**REQUEST**

Current Zoning: UMUD-O (uptown mixed-use district, optional)  
 Proposed Zoning: UMUD-O SPA (uptown mixed-use district, optional, site plan amendment)

The petition proposes to allow up to three electronic changeable copy wall signs totaling a maximum of 5,900 square feet. The site is developed with a mixed-use office tower.

REZONING PETITION
#2023-139
UM-100

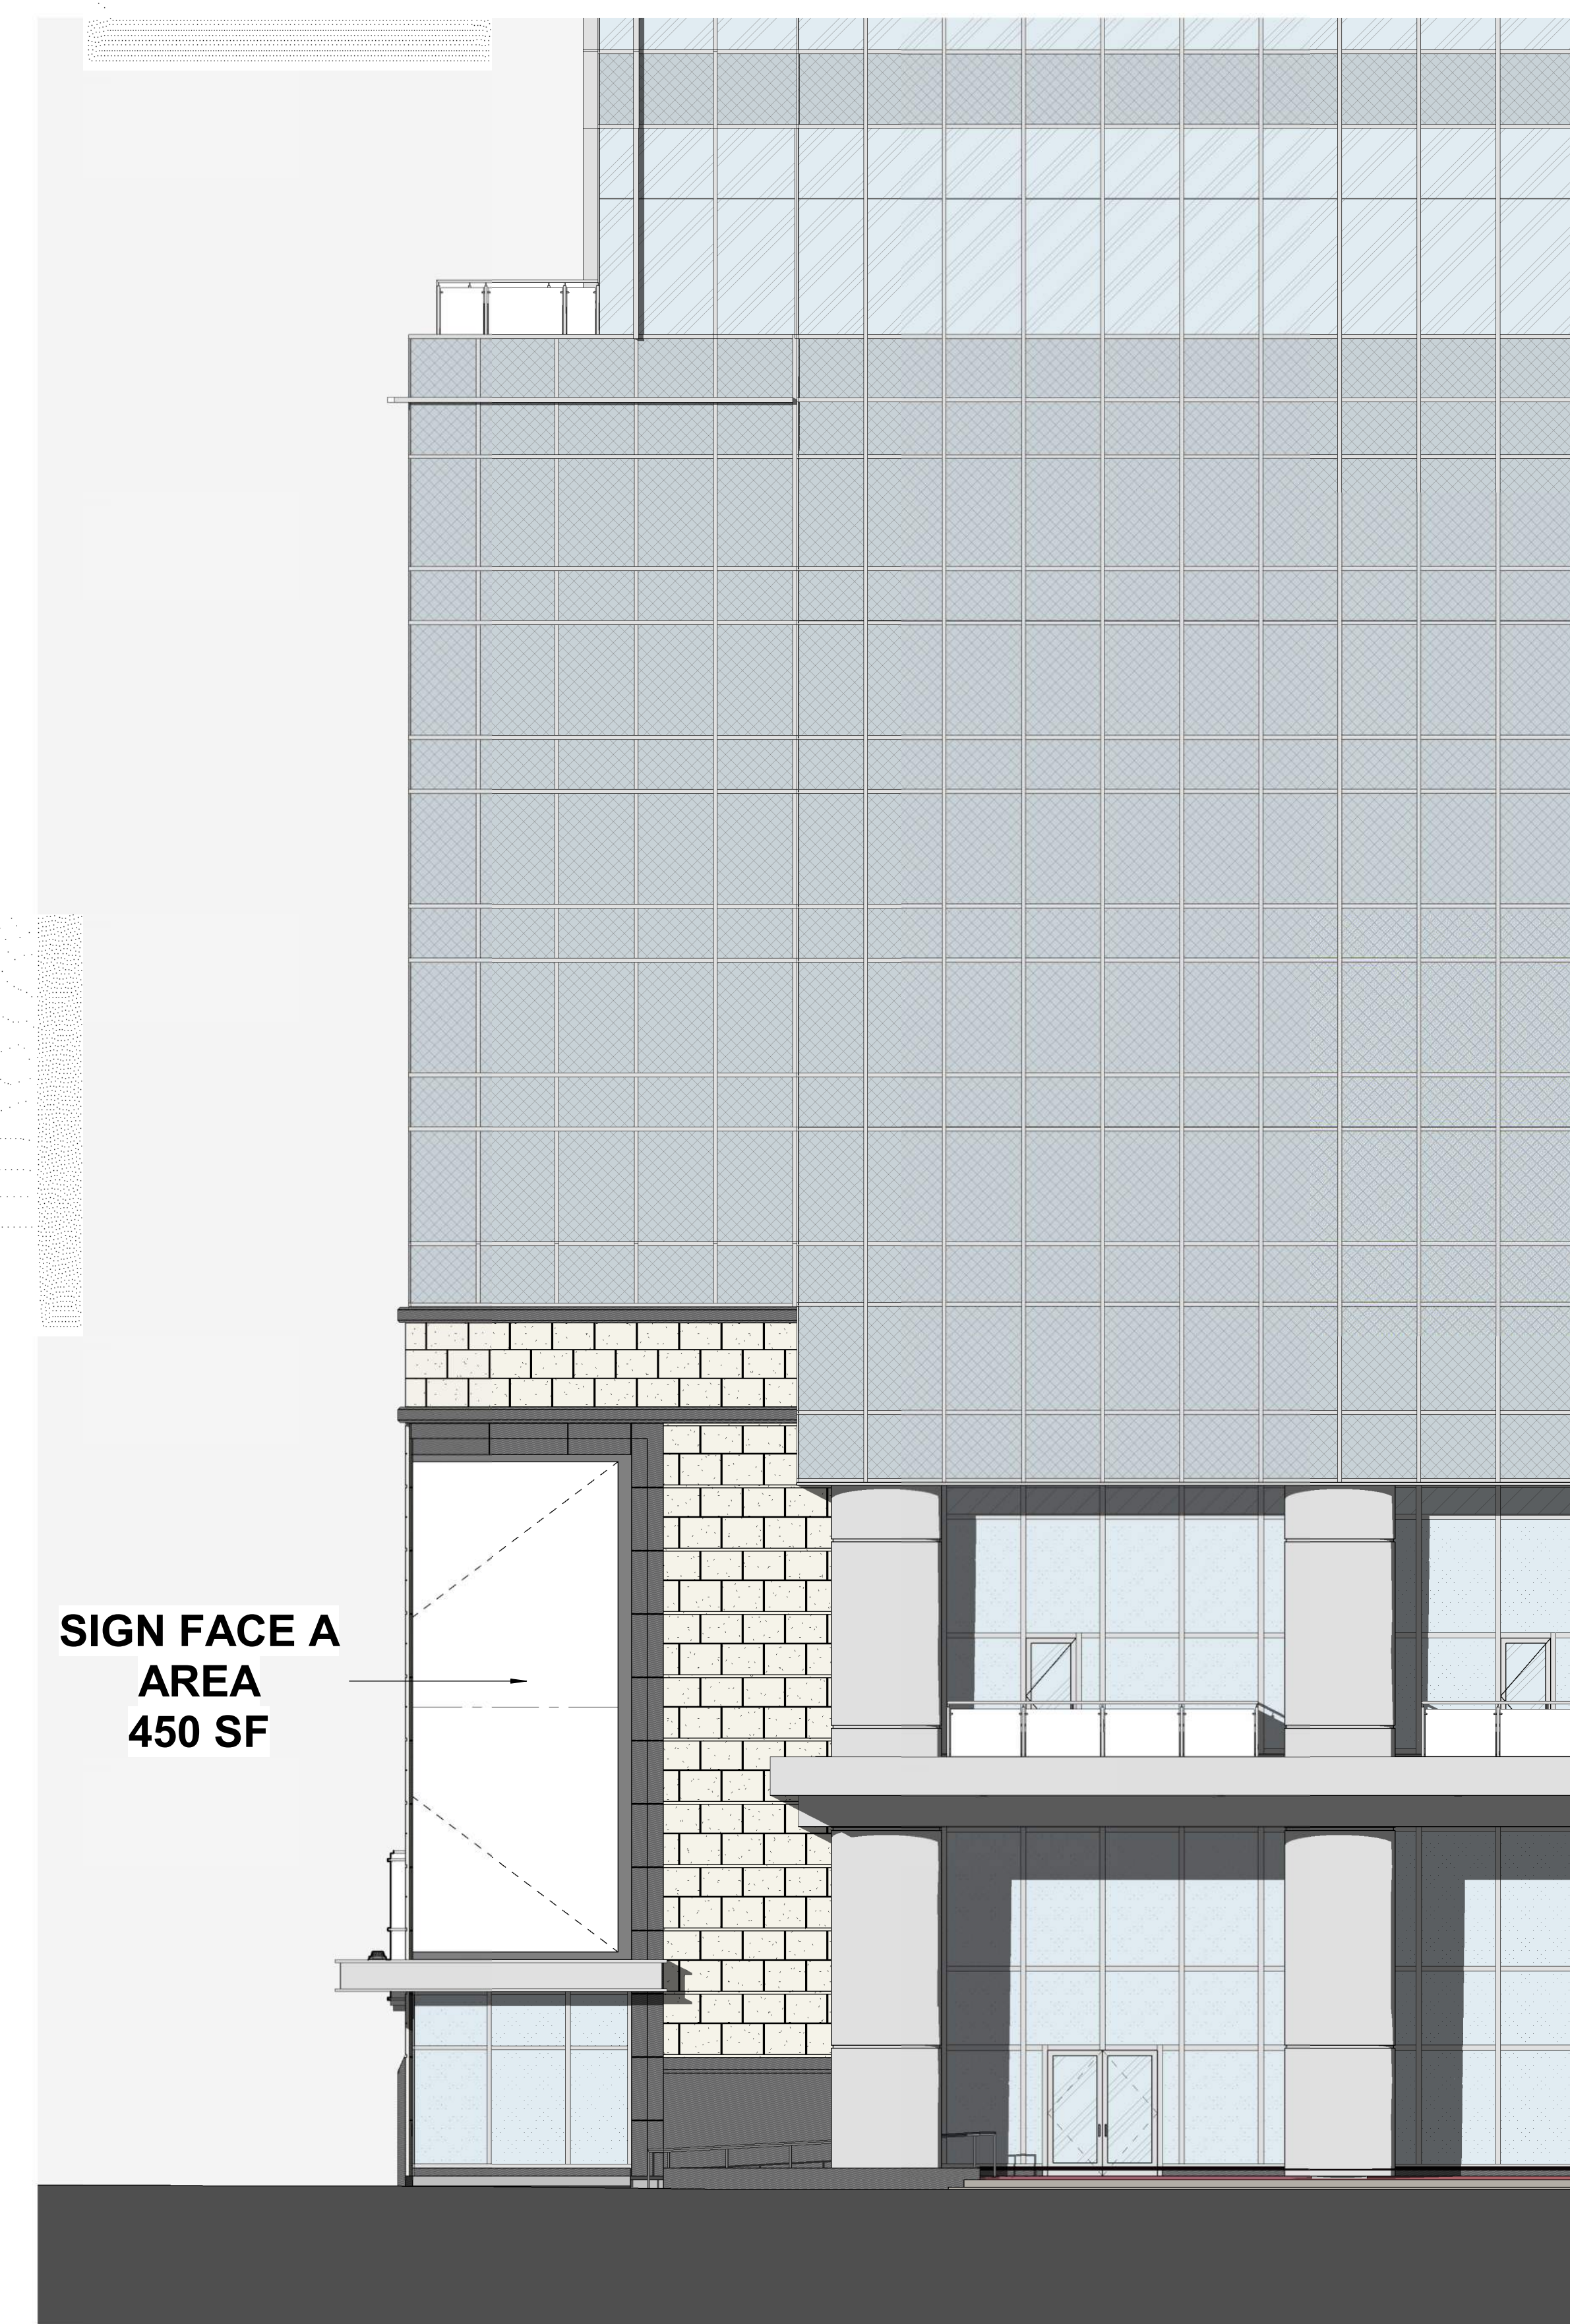
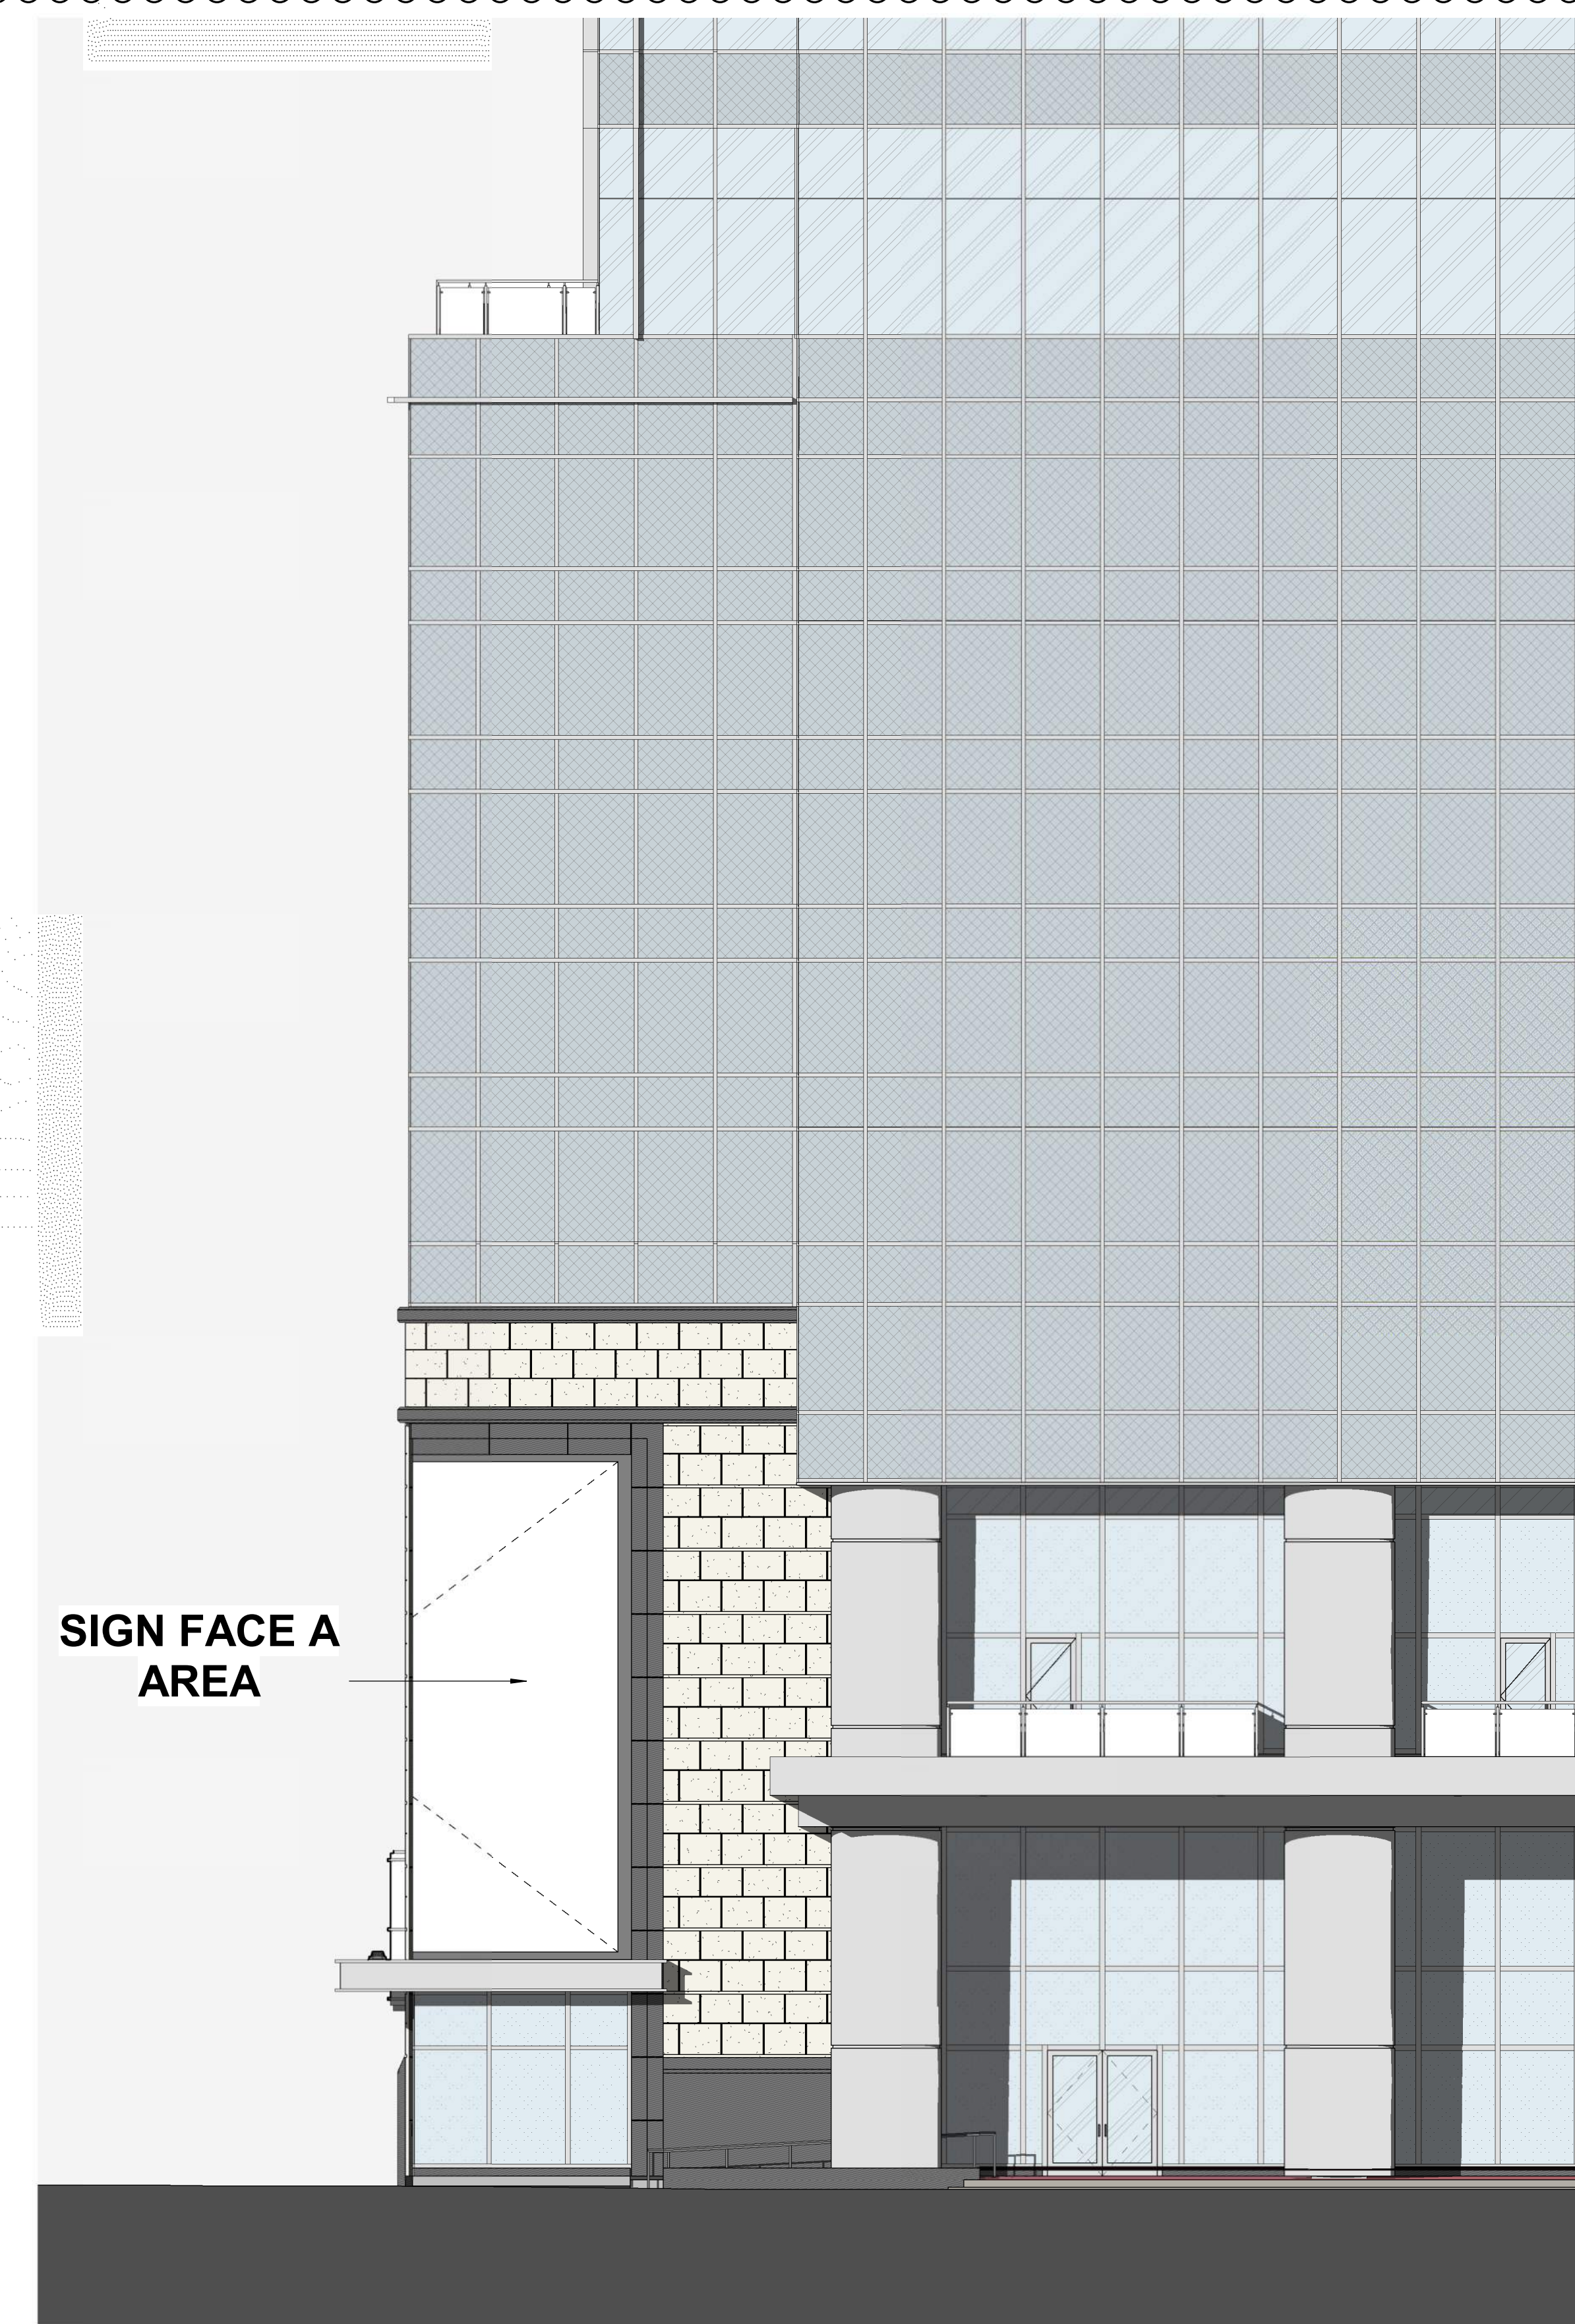
1. The language of the proposed optional provisions should be updated to describe the requested signage as wall signs in accordance with the standards Chapter 13 of the Zoning Ordinance.
-
